Your Ref: OWPC22908
Our Ref: AL/35/19/HH 17-04-2019
Please ask for:
Amber Willard

Single storey rear extension and addition of 1st floor with alterations to fenestrations and internal alterations.

Ashmead Fontwell Avenue Eastergate

Proposed Side Elevation (south)

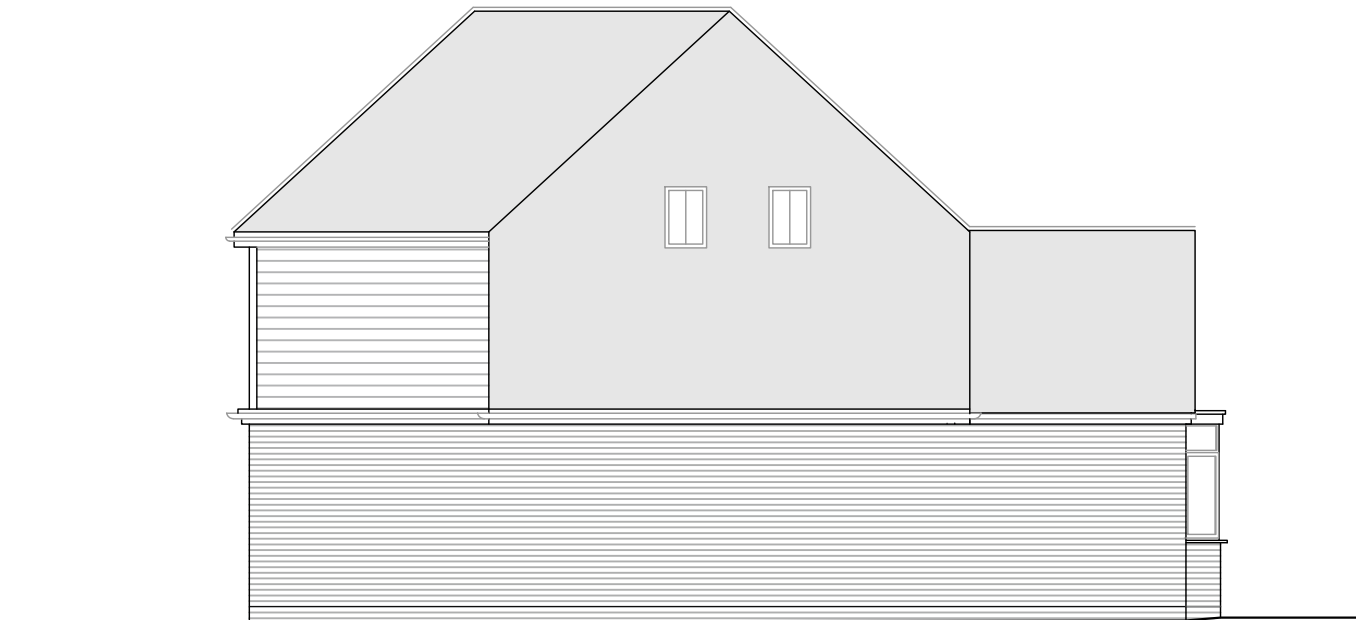
BEING THE OWNERS OF BARKIES, THE BUNGALOW NEXT TO ASHMEAD, WE ARE CONCERNED OVER THE TWO SECOND STOREY WINDOWS WHICH WILL BE LOOKING DOWN INTO ONE OF OUR BEDROOMS AND ALSO OUR LOUNGE, WHICH WE FEEL IS AN INVASION OF PRIVACY, WE ARE ALSO LED TO BELIEVE ONE OF THE WINDOWS IS FOR A BATHROOM ? FURTHER OBJECTION IS TO THE PARKING ON THE PLANS, WE OWN THE RIGHT OF WAY ACROSS ASHMEADS DRIVE AND THIS WOULD OF COURSE PREVENT OUR ACCESS
